**Consultation Response from KC,
Highways Development Management**
2026/91649 The Coach & Horses, Eastgate, Honley, Holmfirth, HD9 6PA
Discharge of details reserved by conditions 8 (access signage/white lining markings), 15, 16, 17 (drainage), 18 (crime/security), 19 (landscaping), 20 (materials), 22 (windows), 23 (doors) on previous permission 2025/93126 for demolition of rear block, erection of rear extensions and alterations to existing building to form 9 apartments including associated works and alterations (within a Conservation Area)
Date Responded: 16/07/2026
Responding Officer: Ryan Kinder
Responding Ref: K3-41/7

2026/91649 The Coach & Horses, Eastgate, Honley.

Application to discharge condition 8 (access signage/white lining markings) on previous permission 2025/93126.

Description
 SITE PLAN WHITE LINING + ACCESS

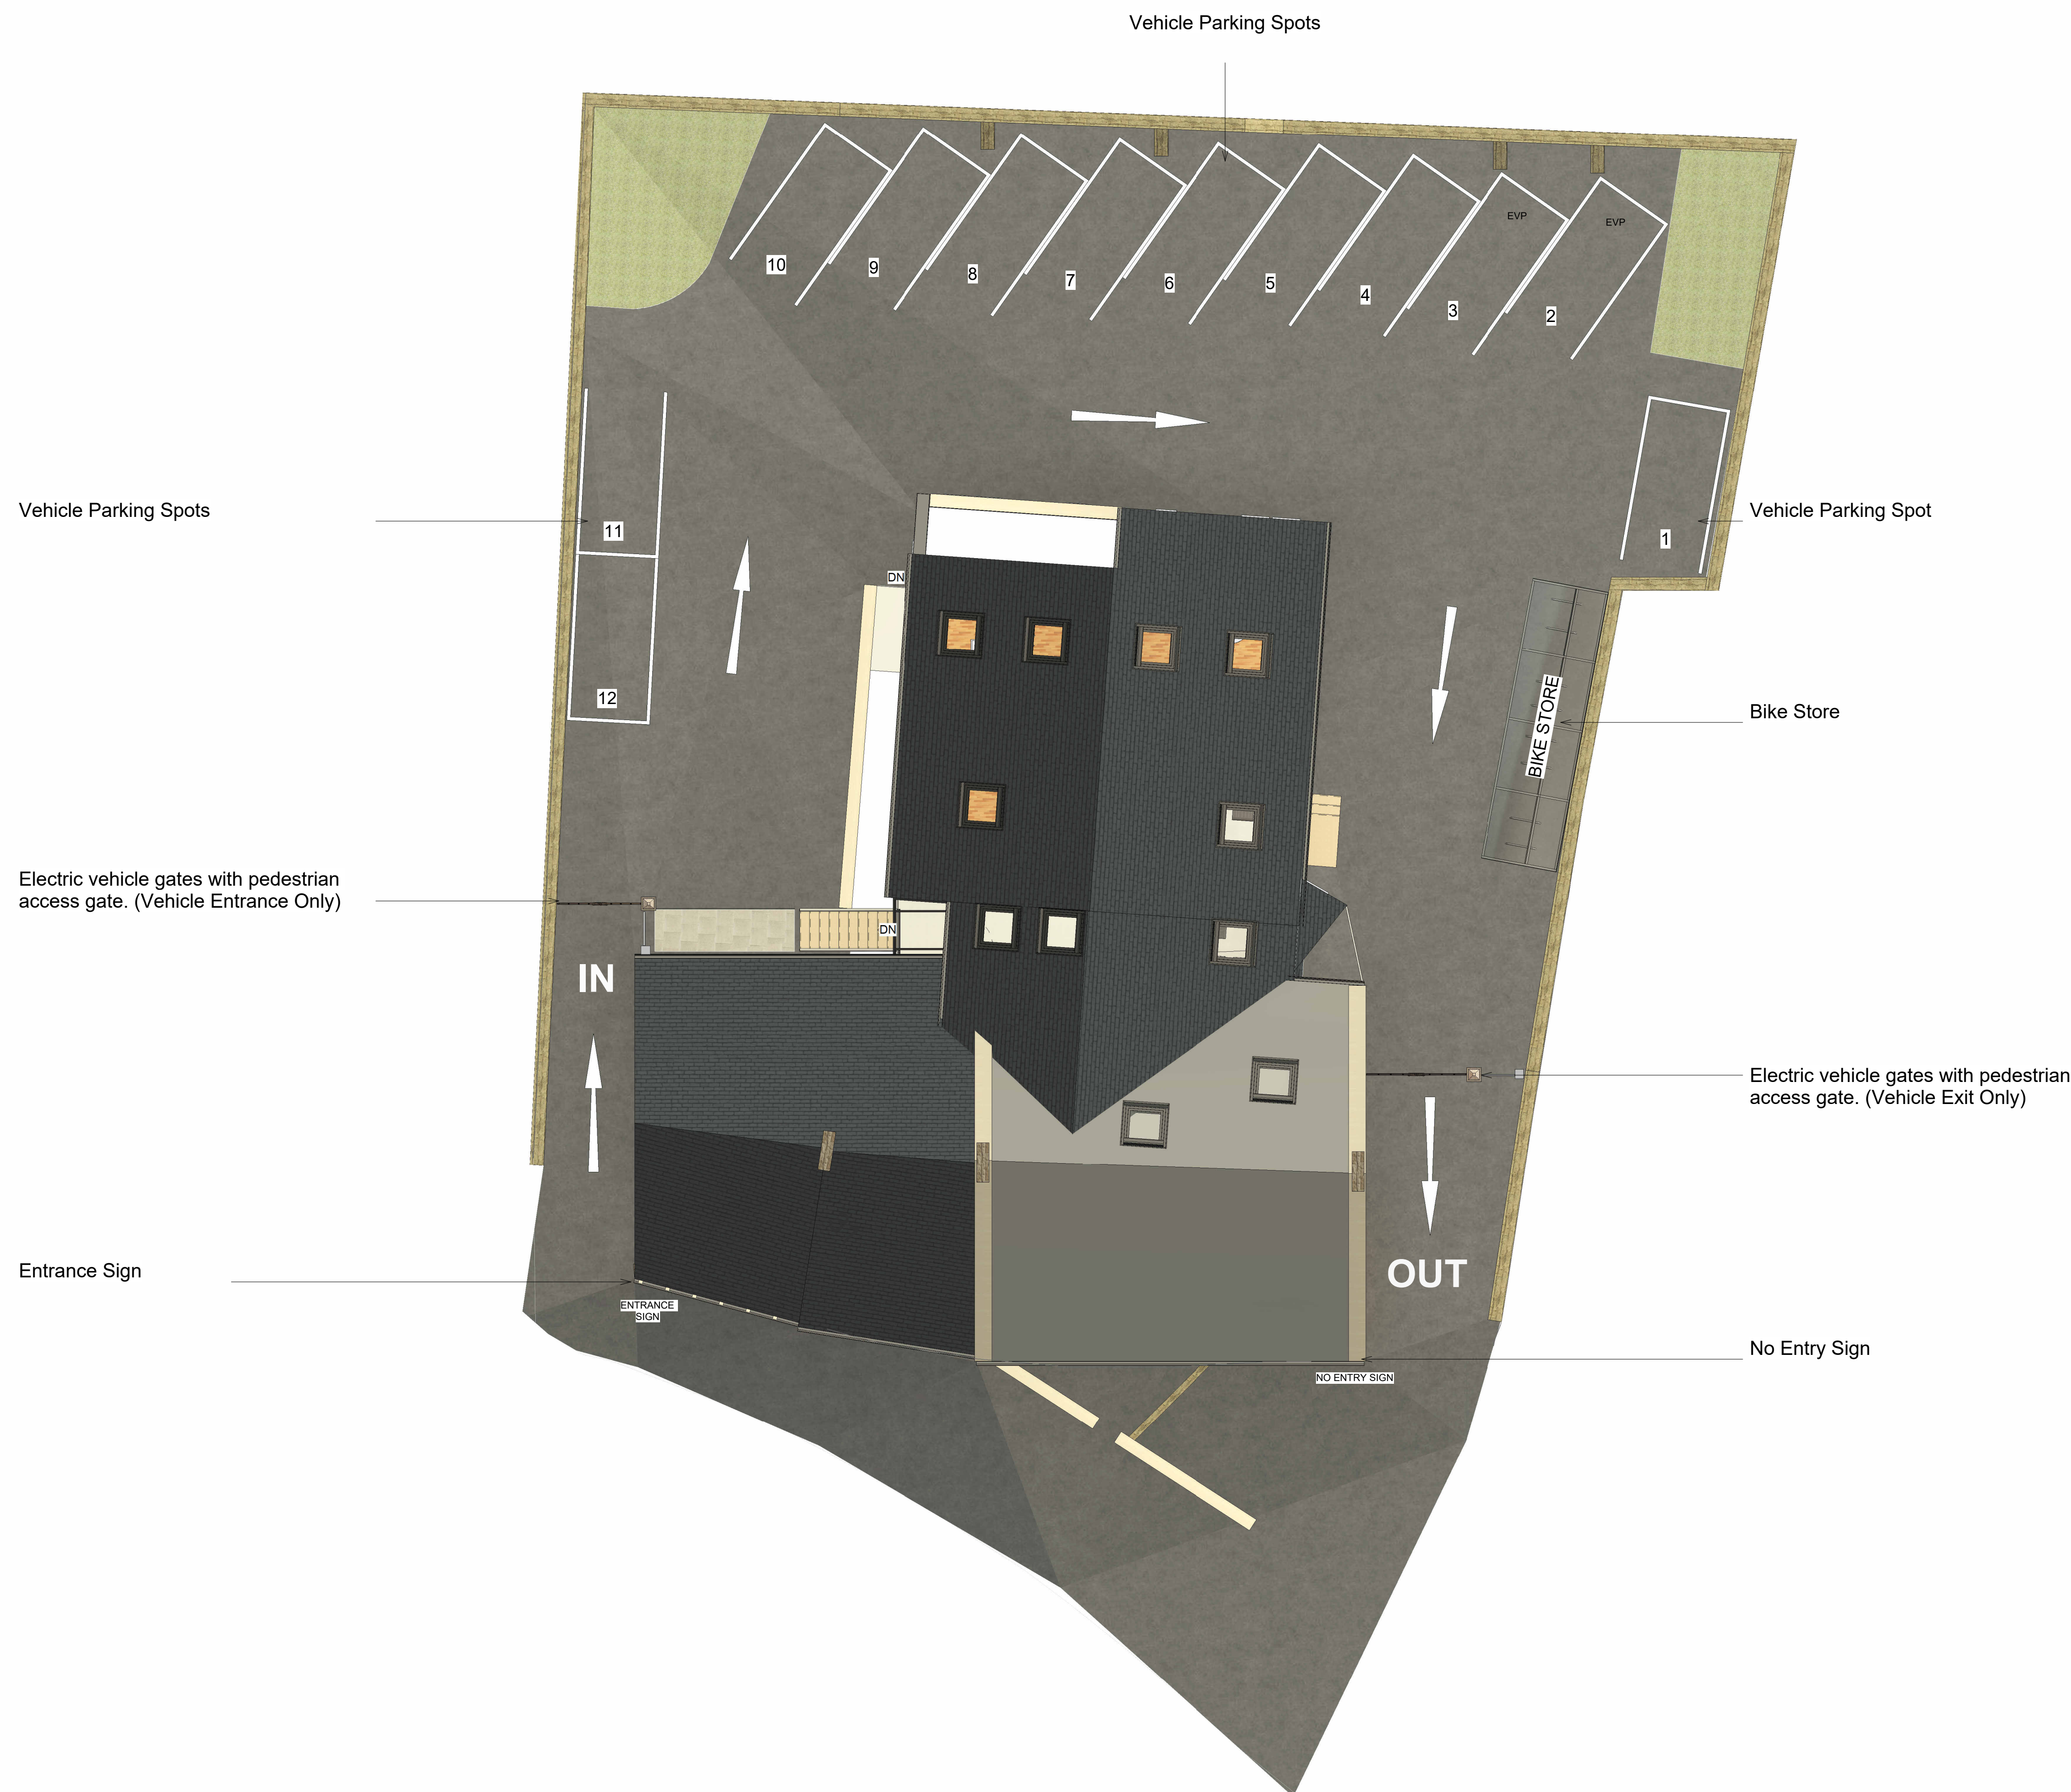
The applicant has submitted a Site plan – white lining and access (ref 2870_(200)10 dated 23/04/2026, which details the access and internal arrangements to be provided on site to ensure the one way in and out is conformed to. This information is considered acceptable for condition 8 to be discharged accordingly.

RECOMMENDATION: Condition 8 (access signage/white lining markings), can be discharged accordingly.
